MECKLENBURG COUNTY  
Park and Recreation Department

MEMORANDUM

**RE:** Rezoning Petition #2024-024  
PID#05142112

# RZ-1.0

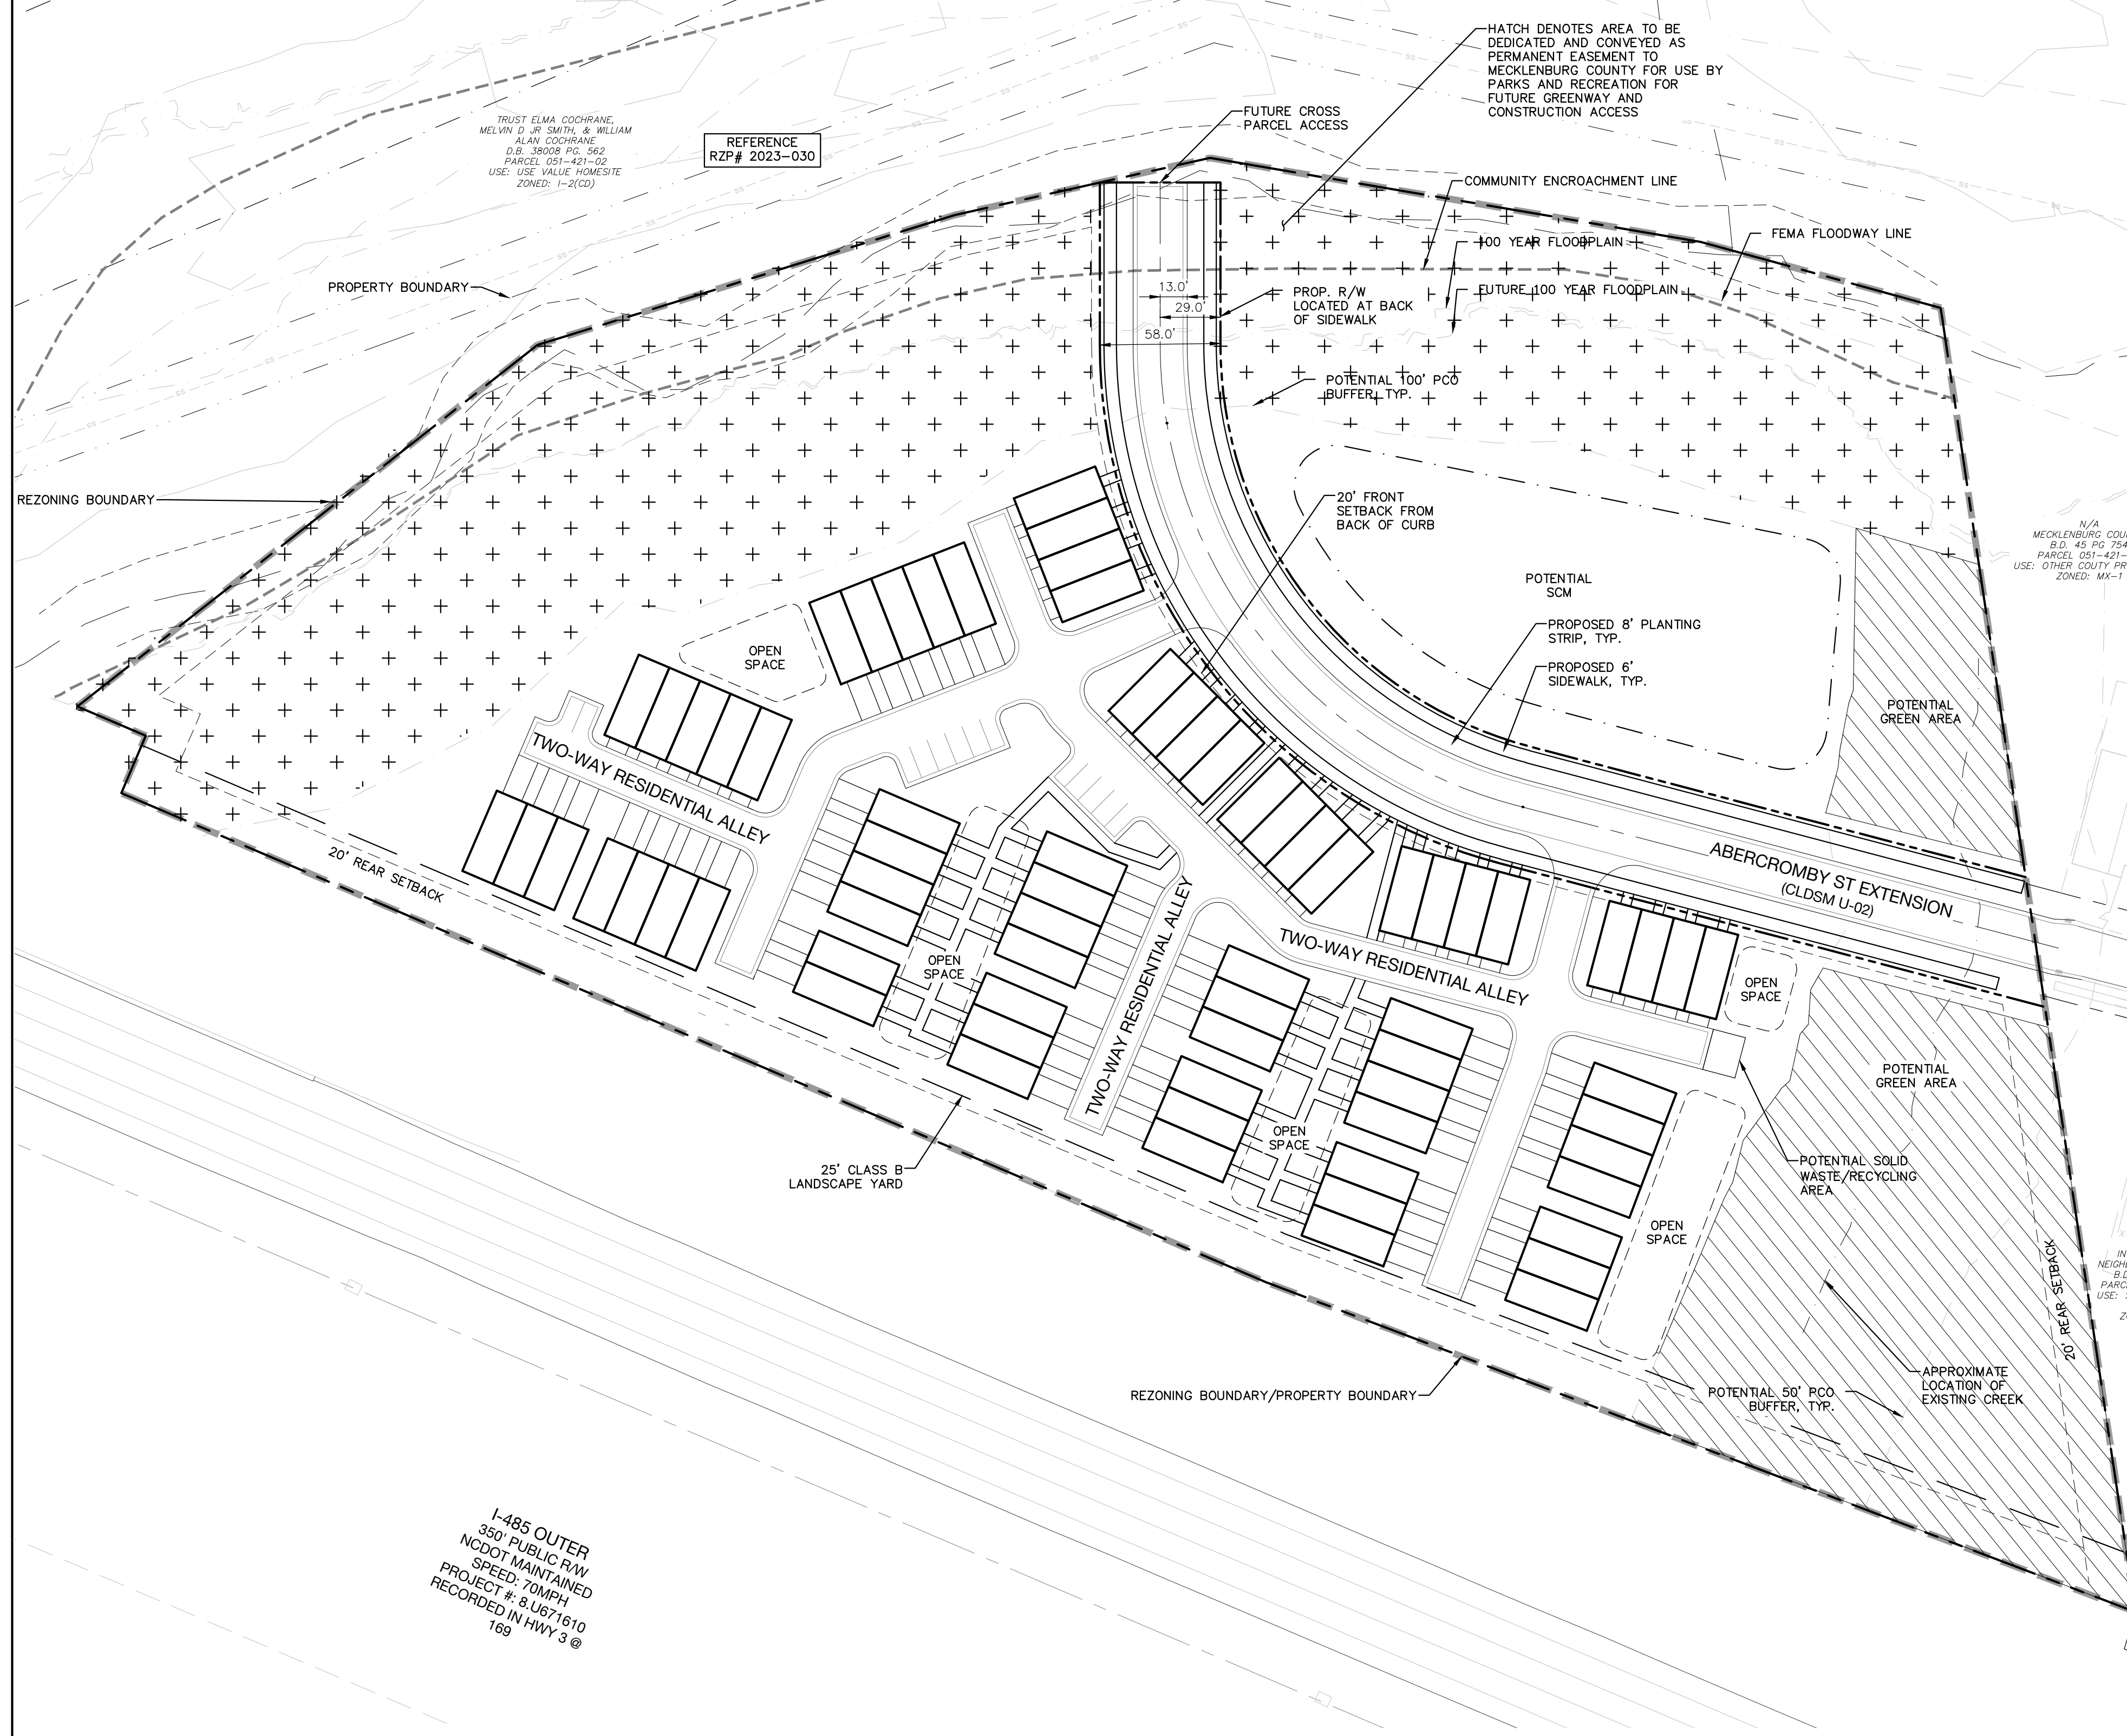
MCPR requests clarification of the hatched area on the current site plan. The Greenway Easement area to be dedicated and conveyed to Mecklenburg County must extend to and connect to both sides of the public ROW.
